**Your Ref:** OWPC19016  
**Our Ref:** BN/23/18/PL 09-05-2018  
**Please ask for:**  
Mr S Davis

Redevelopment of brownfield site previously used for A1 retail to 3 No. dwellings, detached garage & associated works. This application is a Departure from the Development Plan.

37 Hill Lane Barnham

Thank you for your internet representation made on 29th June 2018 which has been recorded as '**an objection**' with the comments as follows:

*plots 1 & 2*

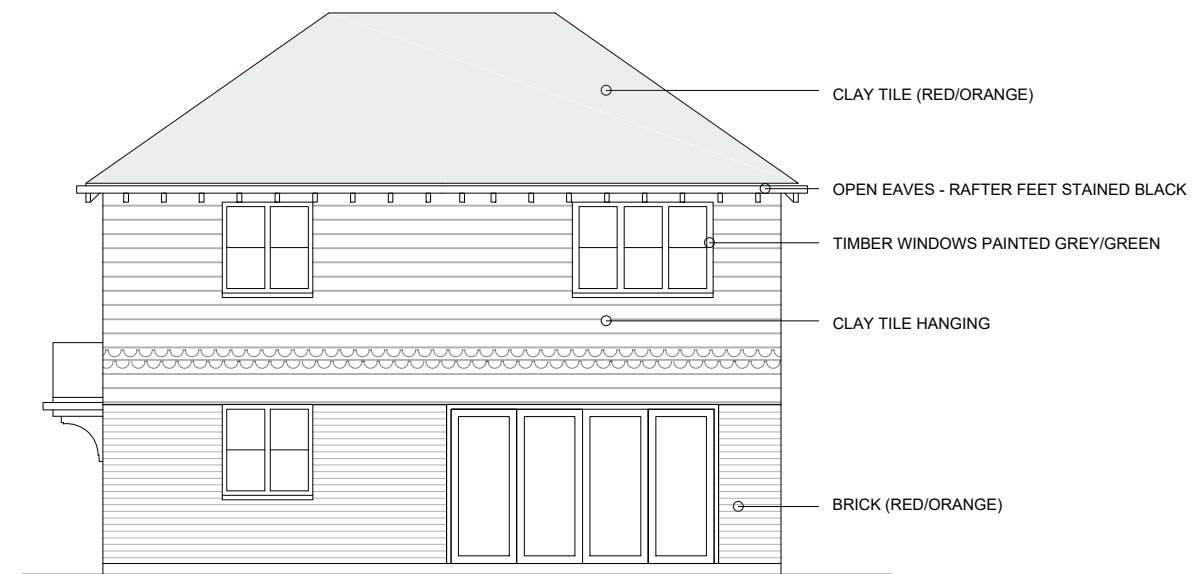
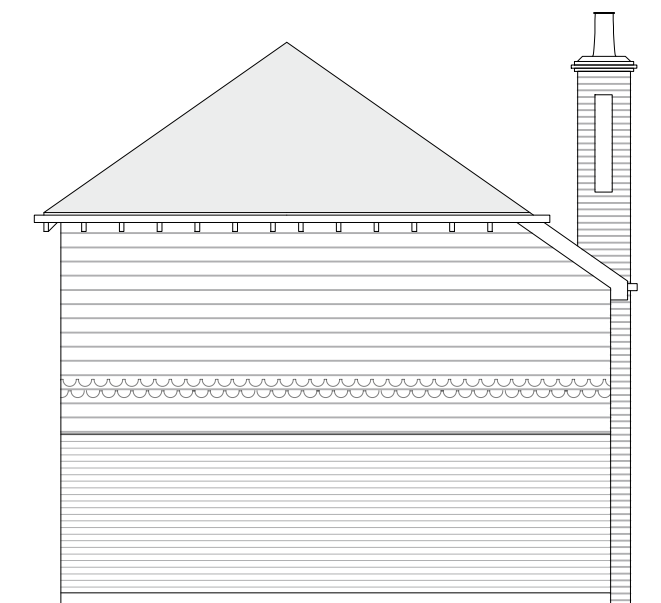
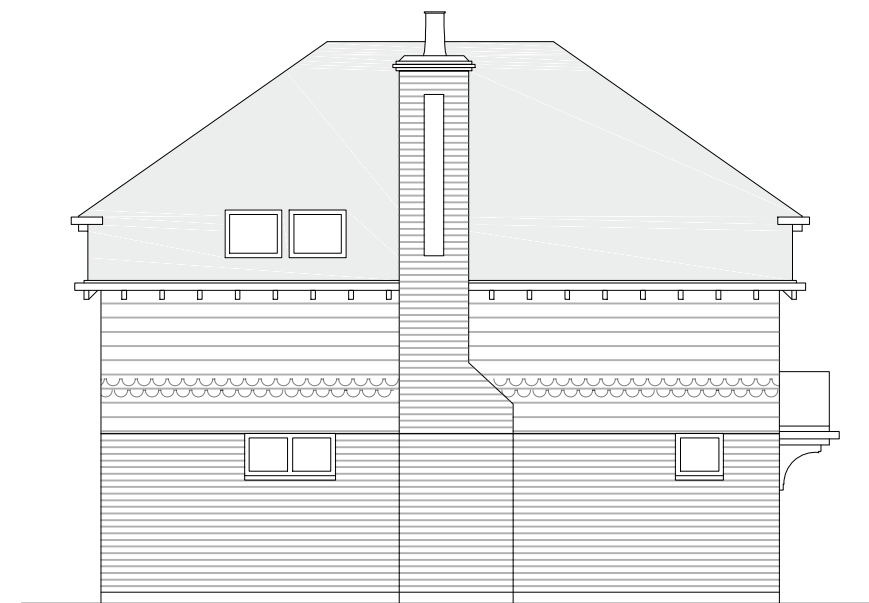
*2: The plots 1&2 , again 2 story would block a large amount of light to its neighbour to the East which would be very detrimental to them and their property.*

*plot 3*

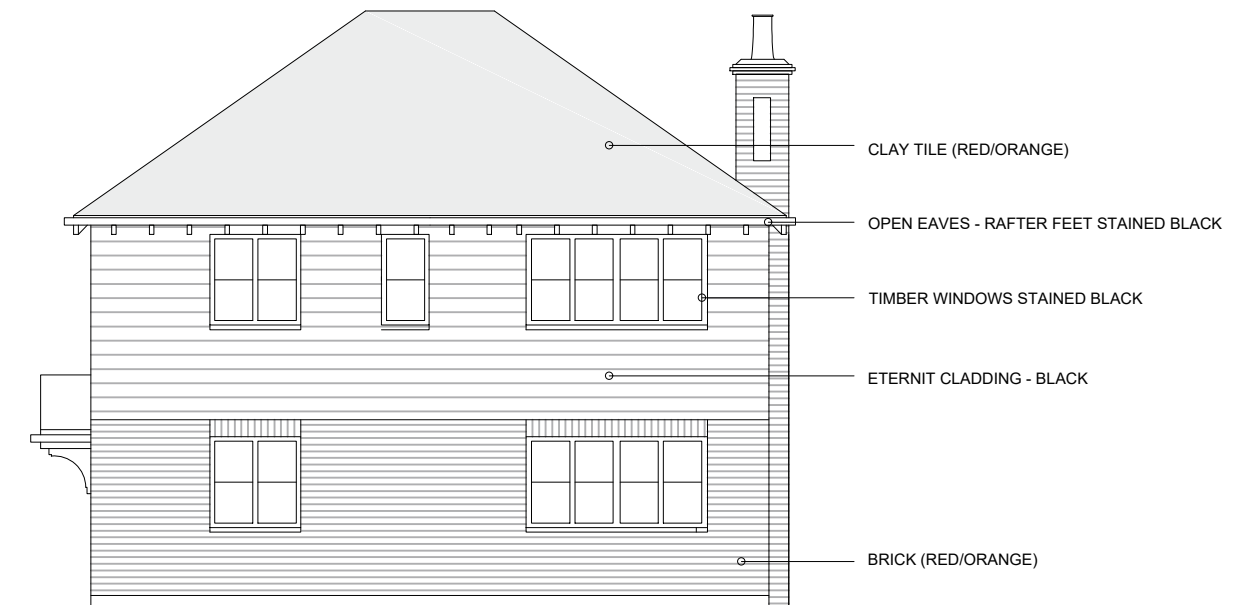
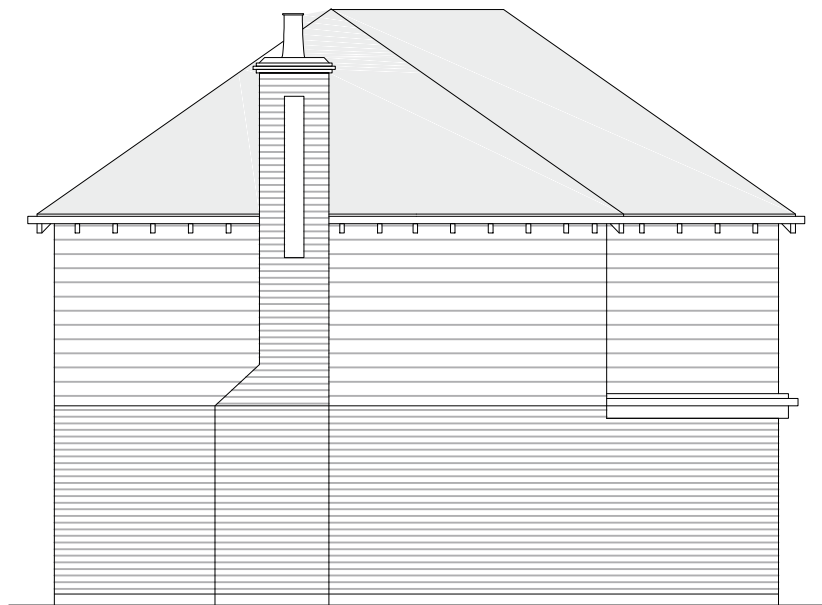
*1: The proposed large 3 bed 2 story building to replace the single story "flower barn" being in front of the building line would be totalling overpowering and alter the character of the lane.*
